Application by Five Estuaries Offshore Wind Farm Limited for the Five Estuaries Wind Farm

The Examining Authority's written questions and requests for information

Issued on 3 February 2025

Figure 2.1: Overview of area of interest for NIP (including concurrent activity working areas).

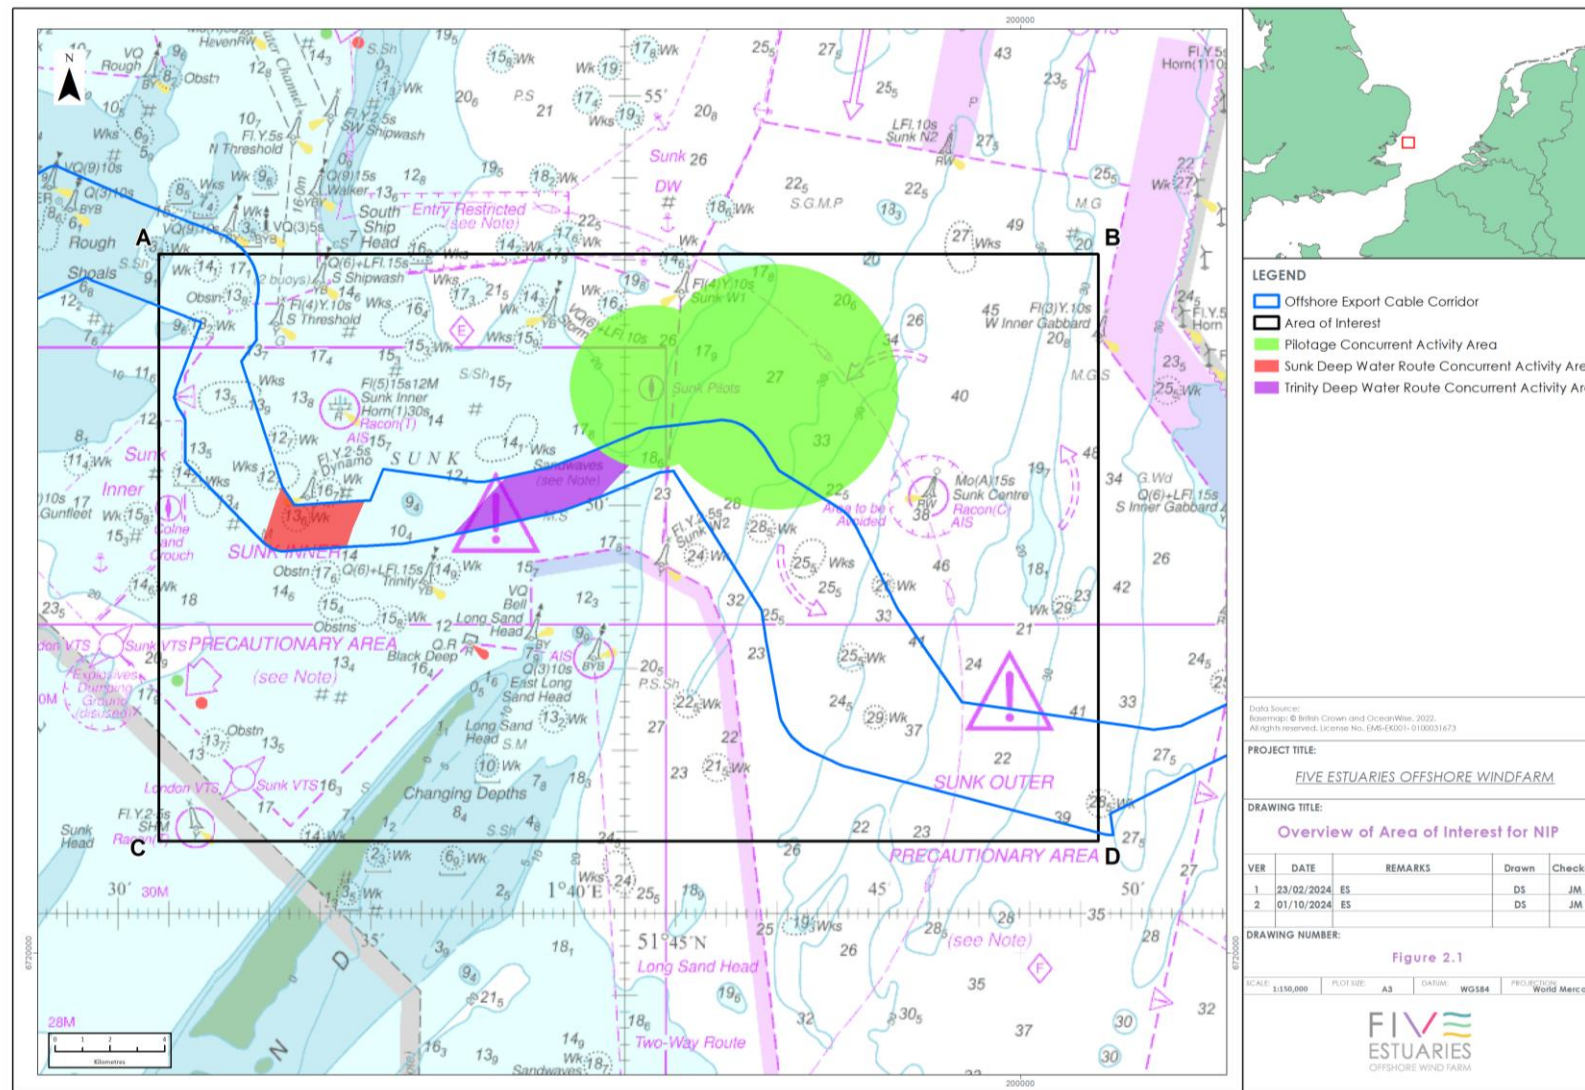
Question to:	Question
EO.3.03	Applicant	<p>National Habitat Networks</p> <p>The route of the onshore export cable corridor bisects or passes in close proximity to a number of “<i>Network Enhancement Zones and Network Expansion Zones</i>,” as illustrated on Drawing 6 in [APP-153].</p> <p>Given that the OLEMP focus for habitat creation in the vicinity of the onshore substation site, in a location that does not appear to provide an opportunity for enhanced connectivity to existing networks, provide an explanation as to why habitat creation in and around the network enhancement and expansion zones has not been considered.</p>
Navigation and Shipping (NS)		
NS.3.01	Applicant	<p>Figure 2.1 in the Outline Cable Specification and Installation Plan (OCSIP)</p> <p>The amended version of the OCSIP submitted at Deadline 4 [REP4-019] at various points refers to Figure 2.1. That figure is included as page 16 of the OCSIP but has not been titled as such. Commitments included in the OCSIP rely on what is shown on Figure 2.1, accordingly for the avoidance of doubt and for ease of use when the OCSIP is next updated the figure included on page 16 should be clearly titled as Figure 2.1.</p>
